**COMMENTARY
ABNORMALS & INFRASTRUCTURE**

MEADOW WAY, SPALDING

CP VIABILITY

AUGUST 2026

1000KEY

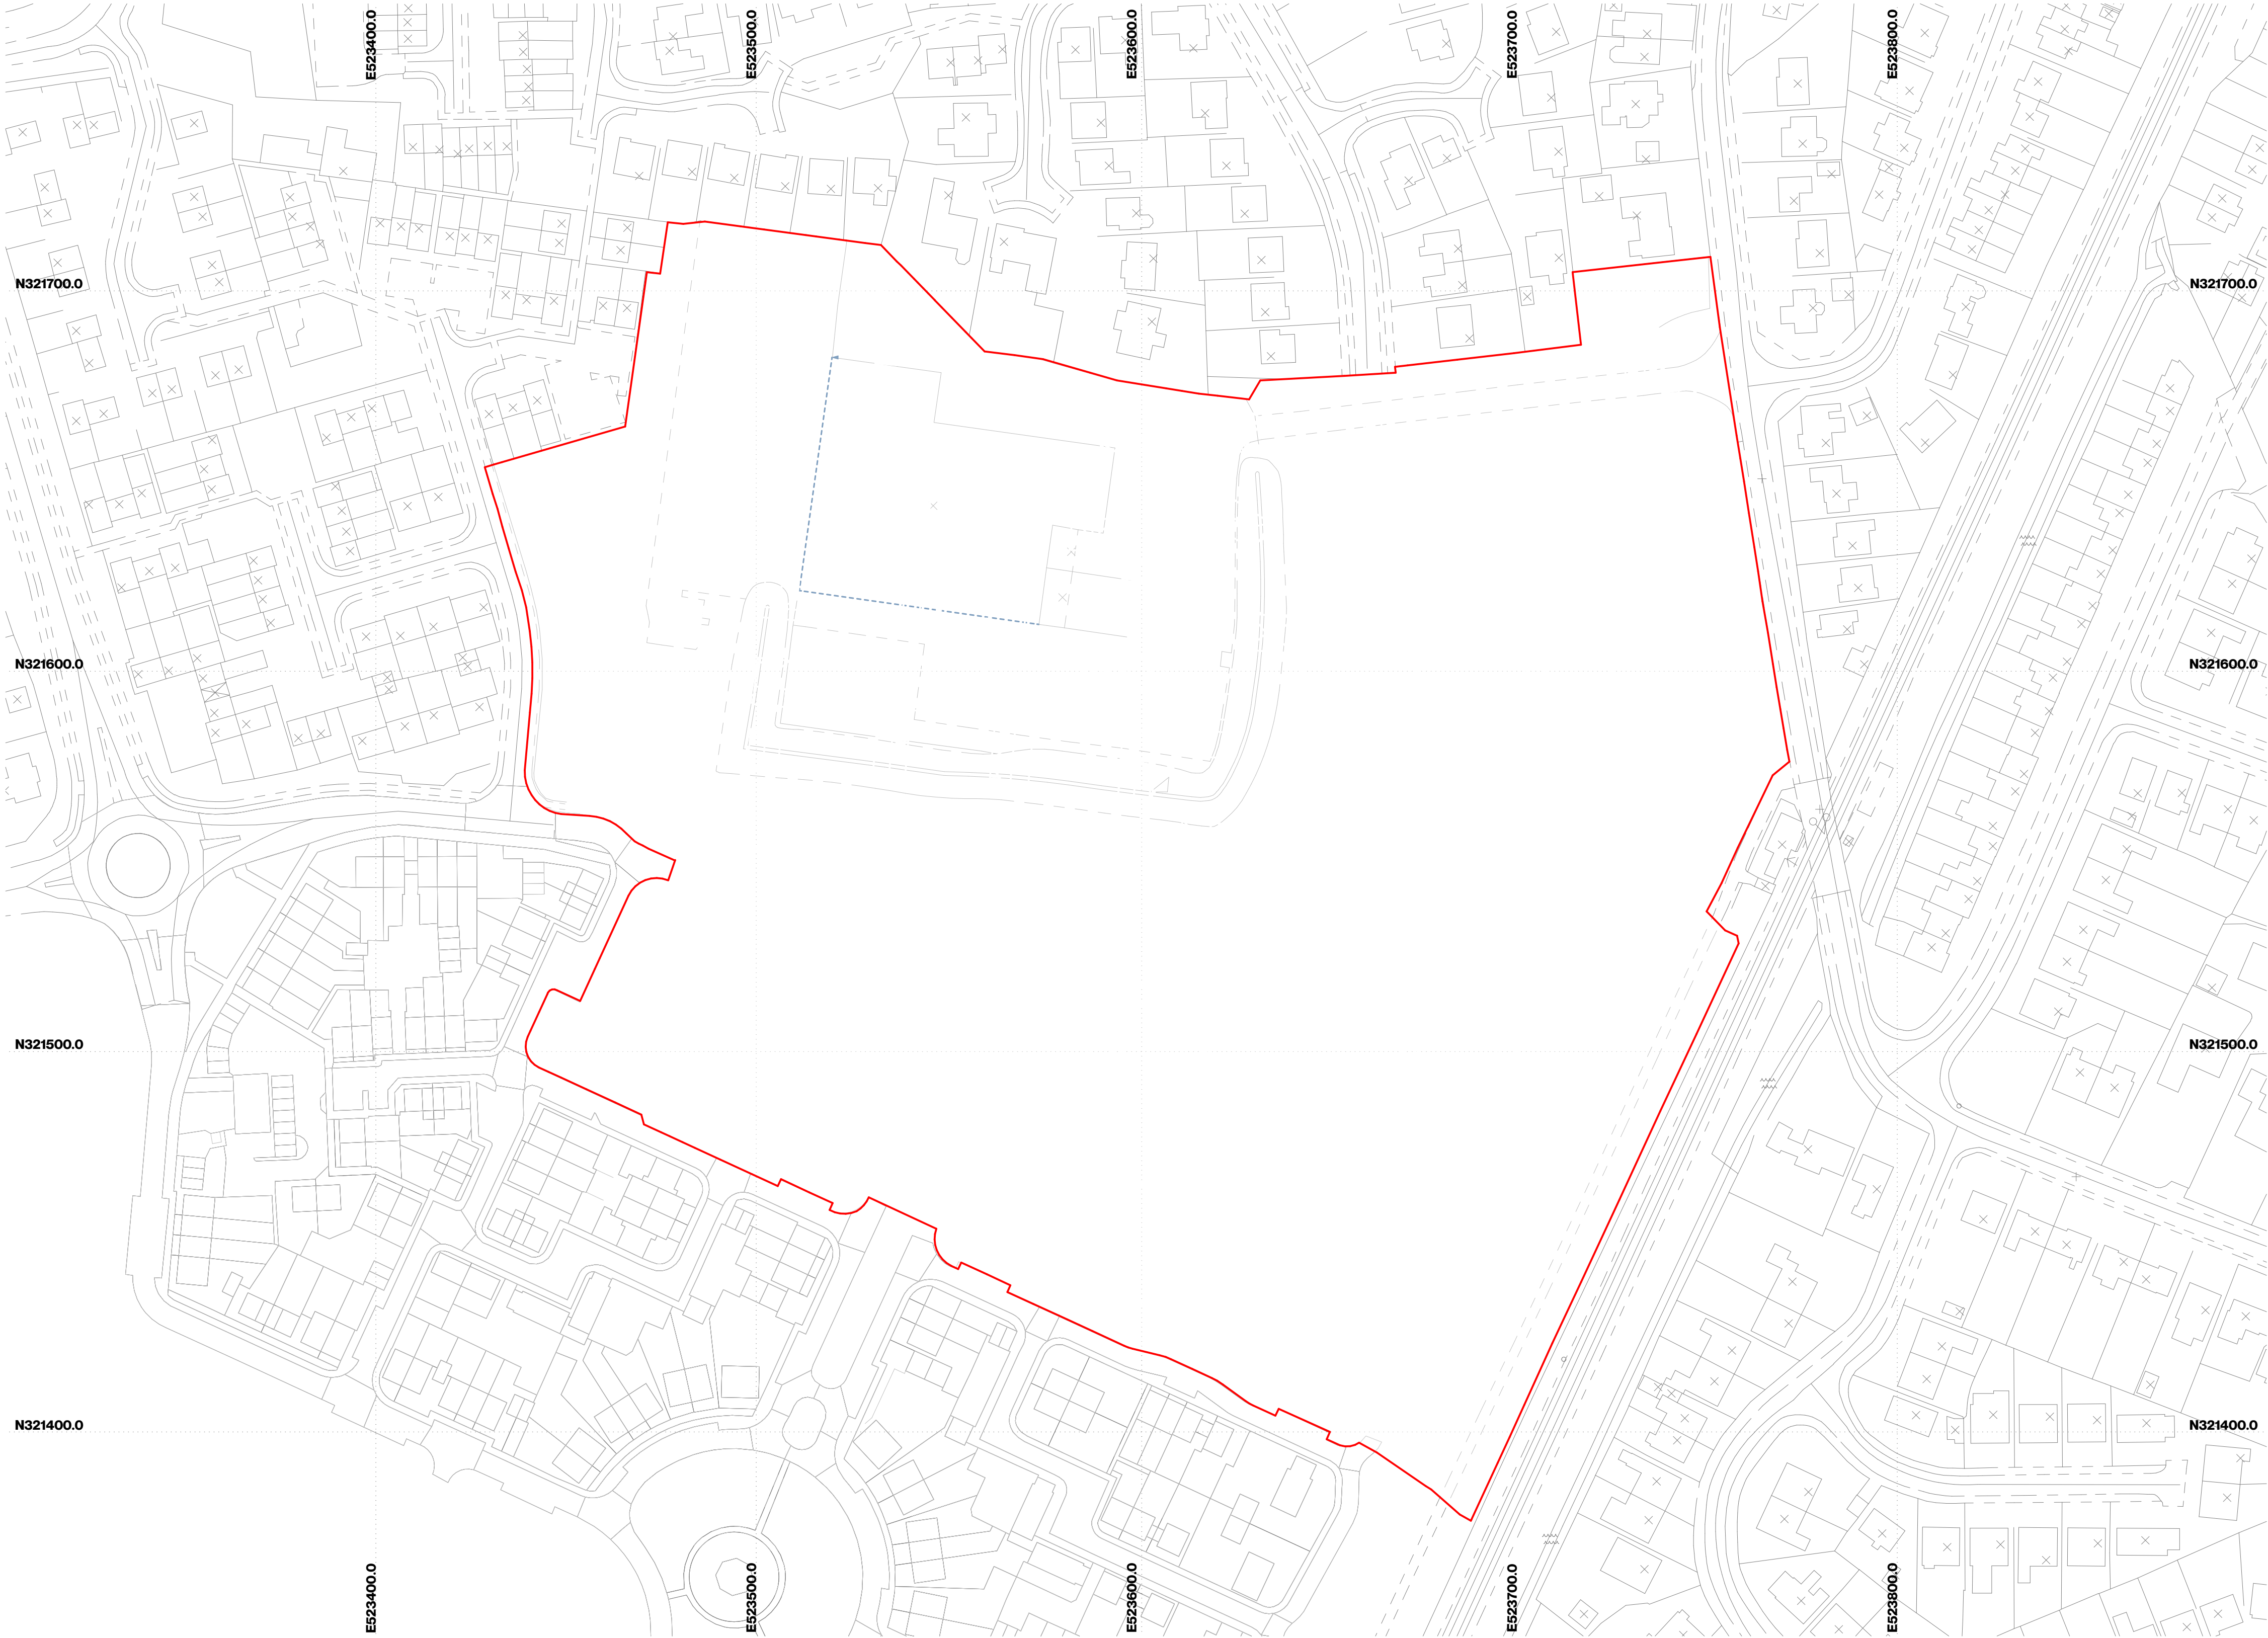
- 4.01 Building Demolition
- We have measured the plan area of the existing warehouse building as 3,780 m² and query the 33,633 m² quantity used by Gleeds. For reference we used 24 Three Site Location Plan drawing 25029-243-XX-XX-DR-A-1000 Rev C02, and we would consider the basis of the £1,177,155 cost to demolish the building to be questionable.
- In our experience, we would consider the demolition of a farm-produce packing facility, including taking up a ground slab, and leaving a level site would be £300,000-£350,000.
